20 December 2021

TfNSW Reference: SYD21/00981/03

Departments Reference: SSD-25725029

**EXHIBITION OF EIS – ARDEX WAREHOUSE & MANUFACTURING FACILITY –
657-769 MAMRE ROAD - KEMPS CREEK**

Super B-Double Quad-Quad
 Overall Length 29.865m
 Overall Width 2.500m
 Overall Body Height 4.300m
 Min Body Ground Clearance 0.540m
 Track Width 2.500m
 Lock-to-lock time 15.000m

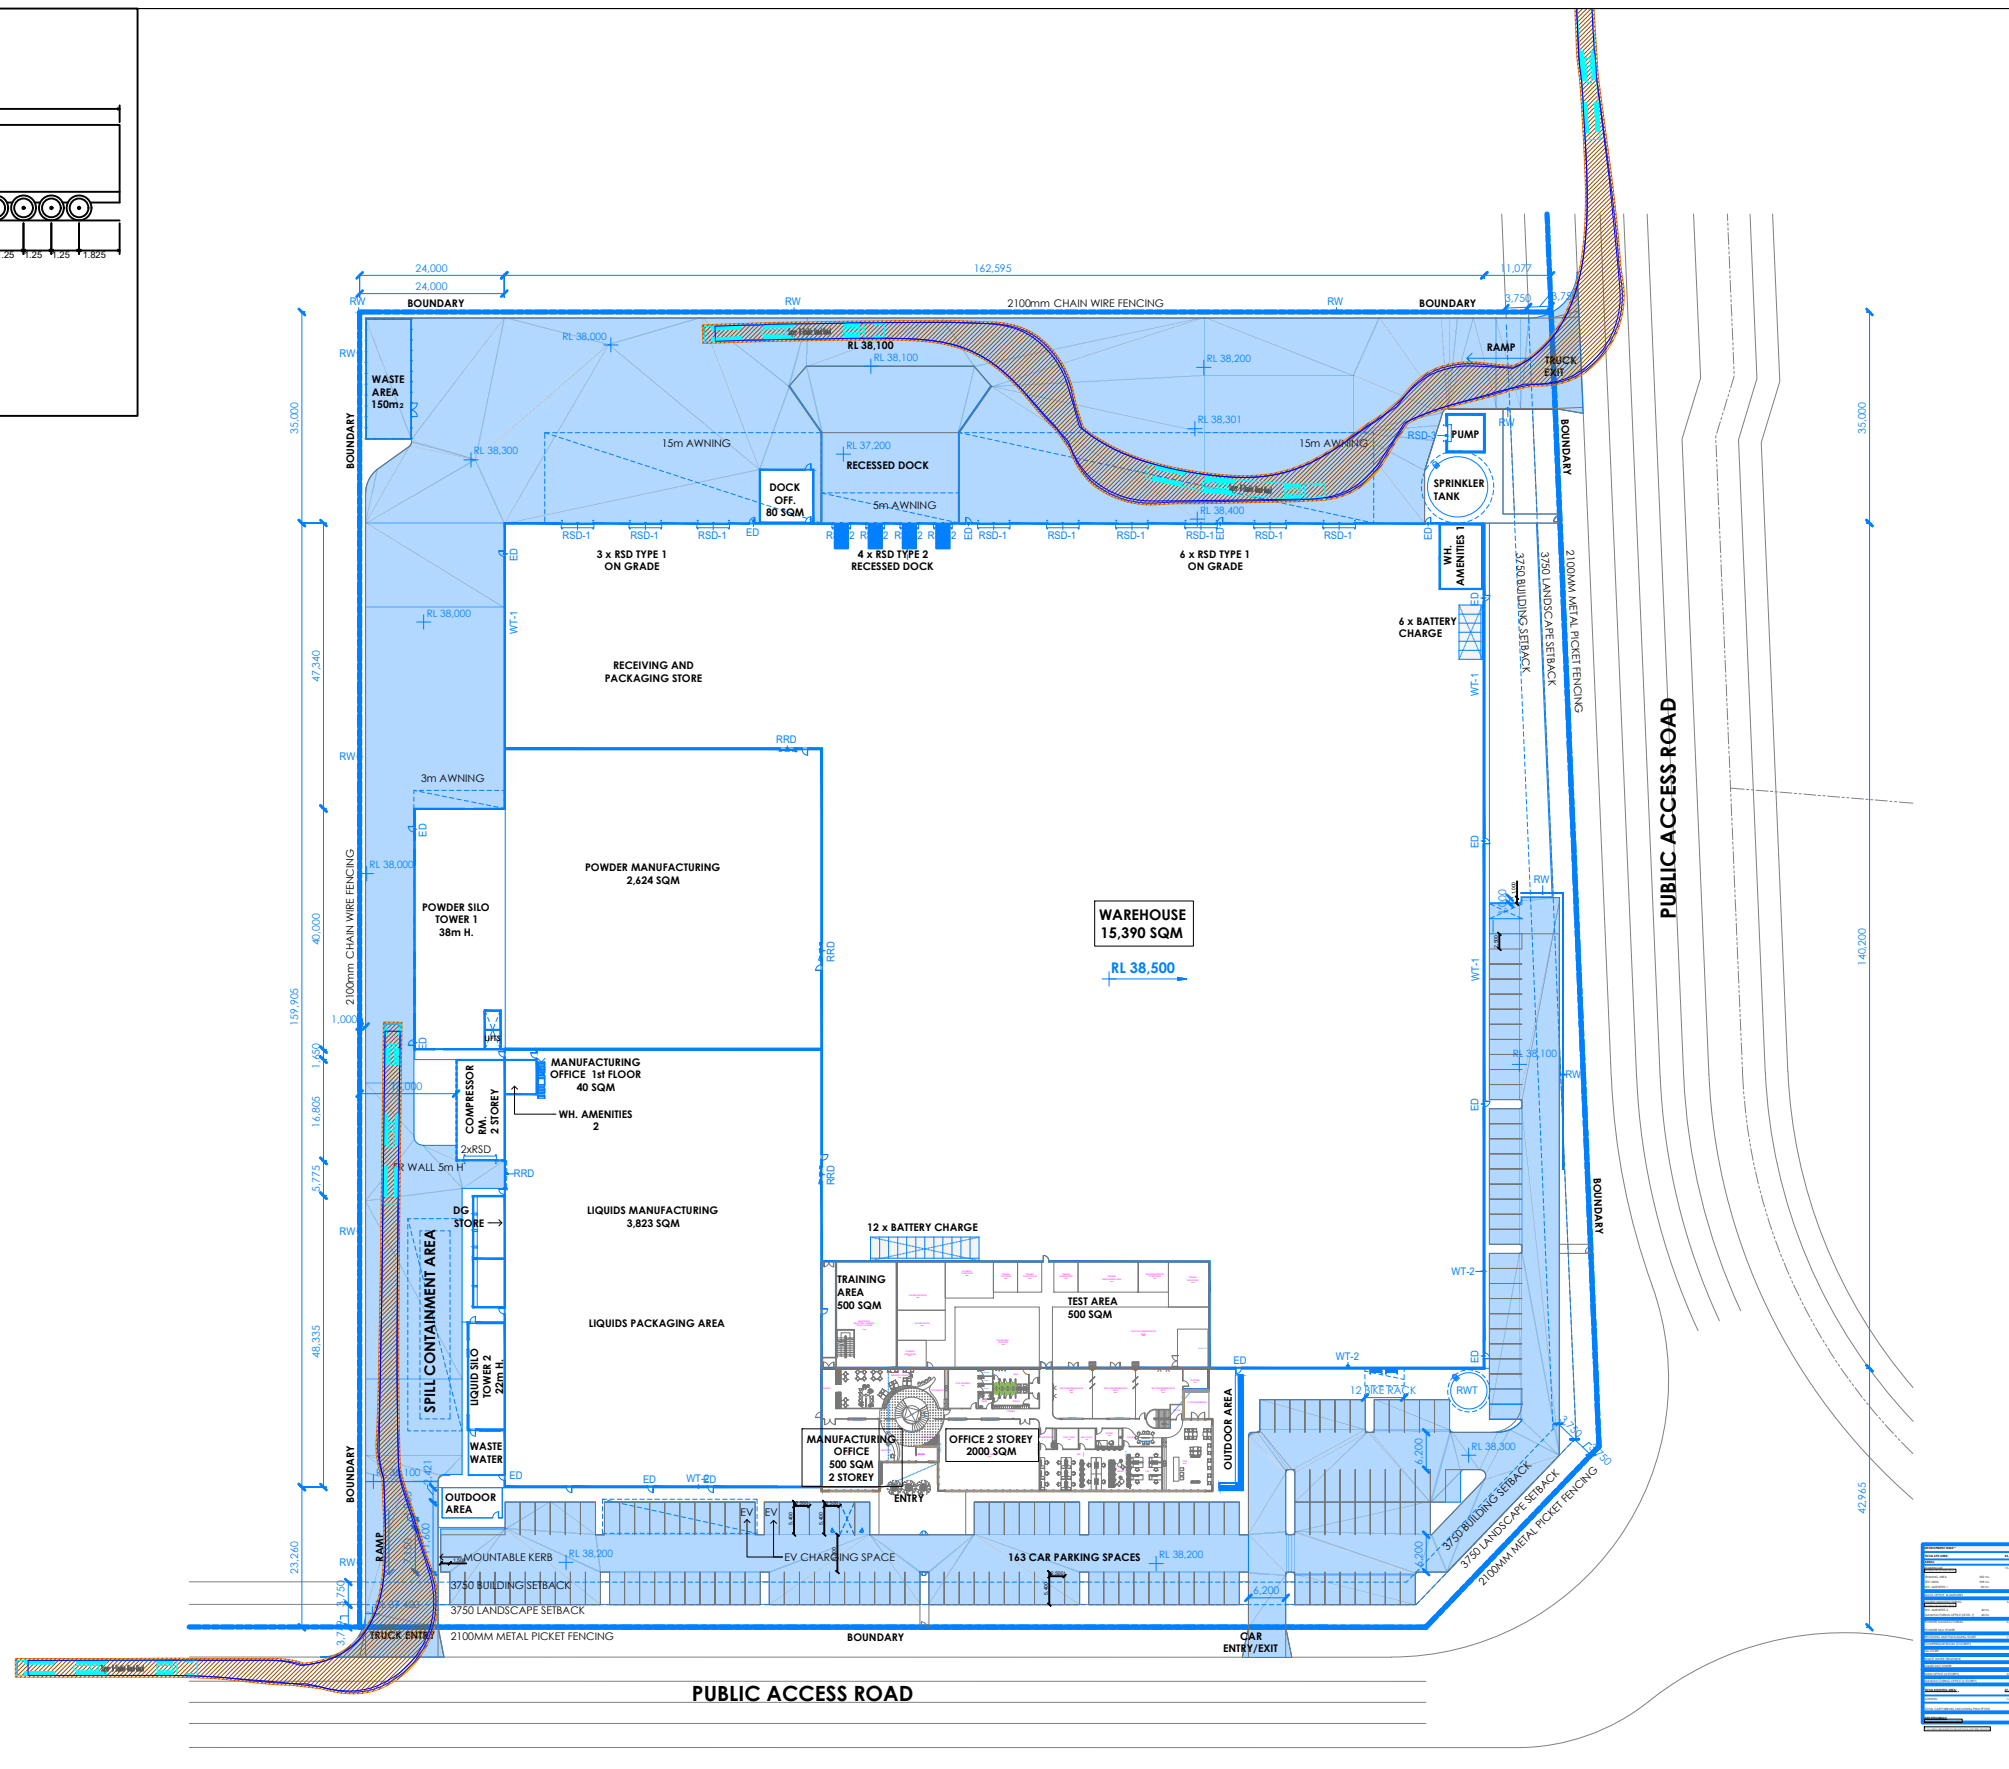
Appendix D – *Swept Path Analysis and Design Commentary* – The swept path plans are provided for 26m A-Double. According to the Mamre Road Precinct DCP Road design item (20), it should be tested for 36m PBS Level 3 type A vehicles.

It is requested that Swept path plans be provided showing the test vehicle of a 36m PBS Level 3 type A vehicle.
